From: [REDACTED]
Sent: 20 August 2026 09:06
To >
Subject: Re: Safer Main Vehicle Access - Northern Phase of Planning Application 3/2025/0997
Importance: High

We are writing to ask that, should planning application **3/2025/0997** be approved, consideration be given to a safer alternative for the main vehicle access to the northern phase of the proposed development.

3.75m wide footway/cycleway.
Can be used as emergency access for Phase 3 North Site and Phase 2. Controlled by knock-down bollards.

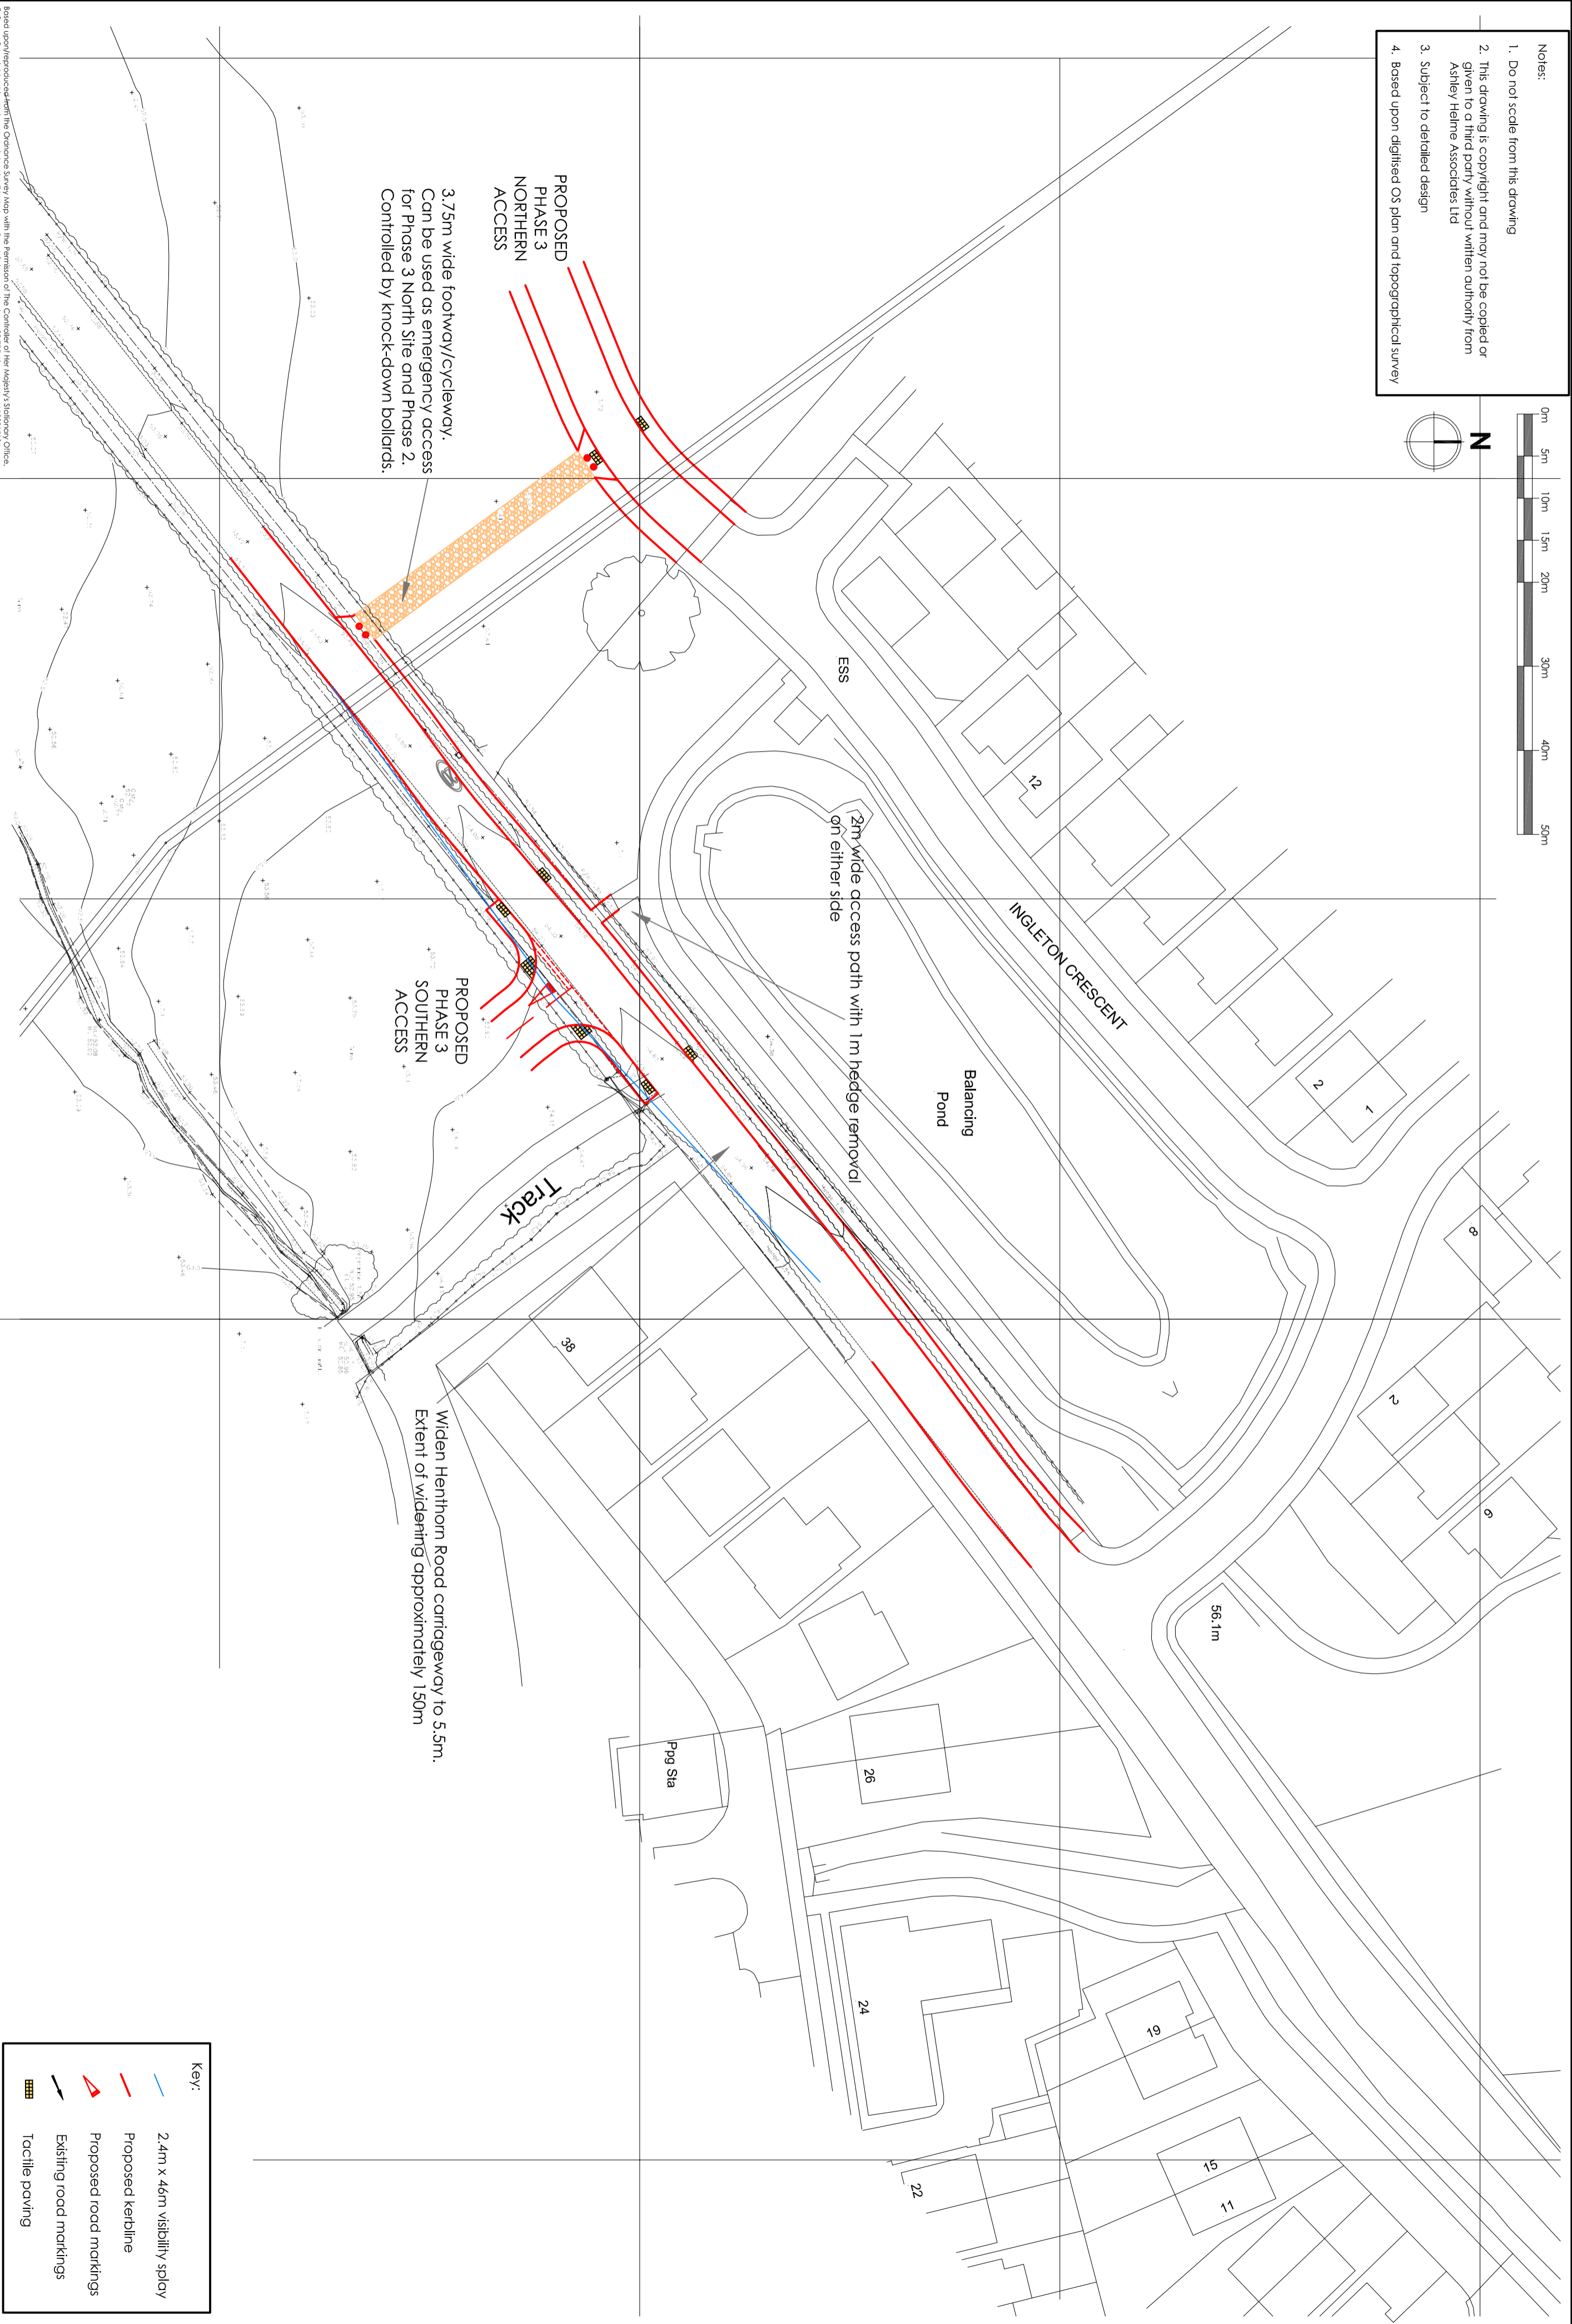
The current plans show a wider emergency access/cycle route directly from **Henthorn Road** (highlighted in orange on the attached plan), alongside a separate main vehicle access via **Ingleton Crescent** and **Waterfall Gardens**. We believe a safer and more practical solution would be to reverse these arrangements, using the Henthorn Road access as the primary vehicle entrance and the currently proposed main access as the emergency/cycle route.

Ingleton Crescent and Waterfall Gardens are not, in our view, suitable for serving as the sole access route for an additional development of 35 houses, which could result in approximately 70 or more additional vehicle movements.

Ingleton Crescent is a narrow residential road with a dog-leg entrance where two vehicles cannot comfortably pass side by side. It leads to a cul-de-sac and runs alongside a water-filled SuDS pond that supports a variety of wildlife, including ducks, herons and deer. The area is frequently used by local residents, families with young children, and dog walkers. Ducks and deer regularly move across and along the roadway, and there is significant pedestrian activity throughout the area.

In addition, a Tree Preservation Order (TP1 on the attached plan) is located close to the proposed main vehicle entrance.

Given these constraints, we believe that using Ingleton Crescent and Waterfall Gardens as the sole vehicle access route would not be the most appropriate or safest solution.

The alternative access directly from Henthorn Road provides a wider, straighter and more direct route into the development. It would avoid directing additional traffic through existing residential streets and would significantly reduce potential conflicts between vehicles, pedestrians and local wildlife.
